Application by Highways England for an Order Granting Development Consent for the A38 Derby Junctions Scheme

Deadline 14 - Position Statement of Network Rail Infrastructure Limited (Interested Party Ref: 20022825)

Planning Inspectorate Reference No: TR010022

Drawing Title  
FIGURE 2.7  
LITTLE EATON JUNCTION  
GENERAL ARRANGEMENT

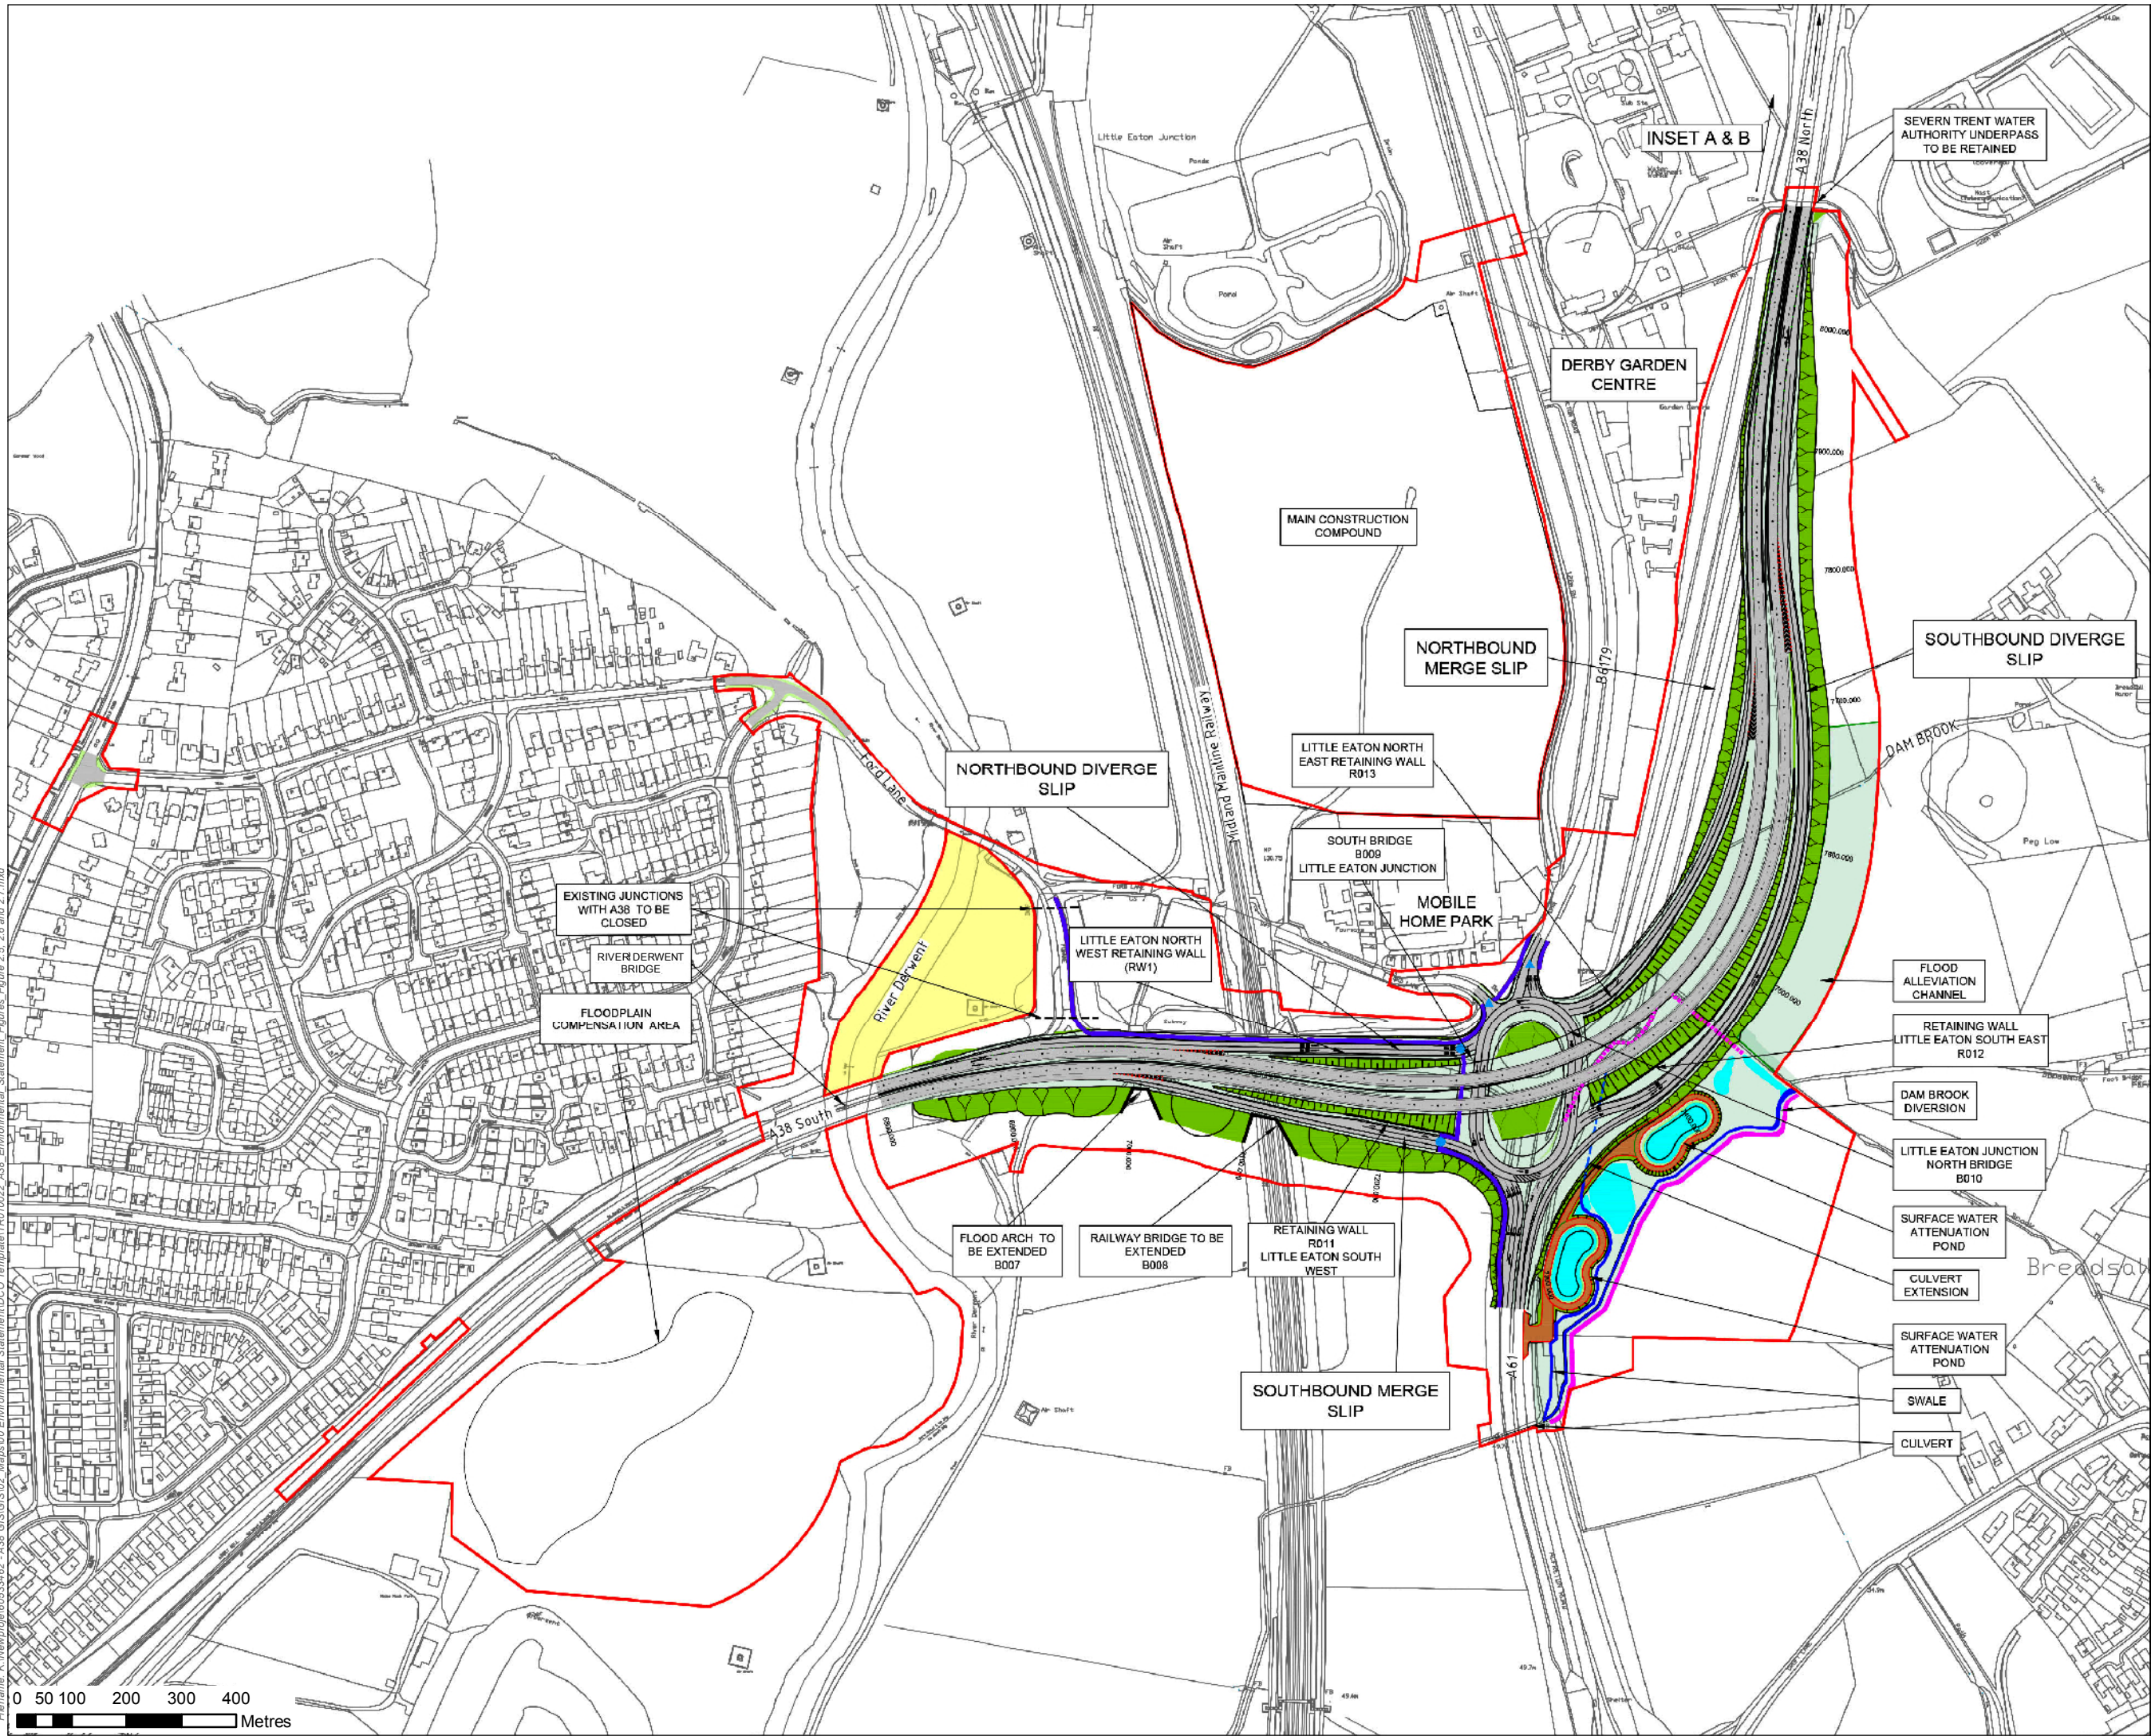
2.1 Network Rail must be able to gain access to the Midland Mainline with vehicles weighing 40 Tonnes for maintenance purposes via the A6 (Ford Lane). As the Applicant's scheme provides for the closure of the access to Ford Lane from the A38, it is essential that the junction between Ford Lane and Duffield Road and the junction between Ford Lane and Lambourn Drive are upgraded to enable access by 40 Tonnes vehicles. Similarly, the Ford Lane Bridge over the River Derwent must be suitable for 40 Tonnes vehicles.

- asked that Requirement 12 in the draft DCO be amended to provide that Derbyshire County Council must approve the detailed design of the Ford Lane/A6 Duffield Road junction and Ford Lane/Lambourn Drive junction works and the Ford Lane Bridge works in consultation with Network Rail; and
- noted that it had not seen the design of the proposed junction or the verification study confirming the load bearing capacity of the bridge.

2.6 Network Rail notes the stance the Applicant has taken. But it is Network Rail's obligation to safeguard its statutory undertaking. Network Rail is content to rely on the approval of the junction works and the bridge load bearing capacity by the local highway authority provided a Requirement is included in the DCO that the junction to Ford Lane from the A38 may not be closed until the Ford Lane/ A6 Duffield Road junction works and the Ford Lane/Lambourn Drive junction works have been constructed and completed to the satisfaction of the relevant highway authority and the highway authority has confirmed that the Ford Lane Bridge is suitable for 40 tonnes vehicles. We ask that a new Requirement 18 is included in the DCO:

18. No part of the authorised development to stop up the access to Ford Lane via the A38 (Works No. 28) shall commence until Works No.s 29, 33 and 34 have been completed to the satisfaction of the local highway authority and the local authority has provided confirmation in writing that the Ford Lane Bridge over the River Derwent has suitable load-bearing capacity for vehicles weighing 40 Tonnes.
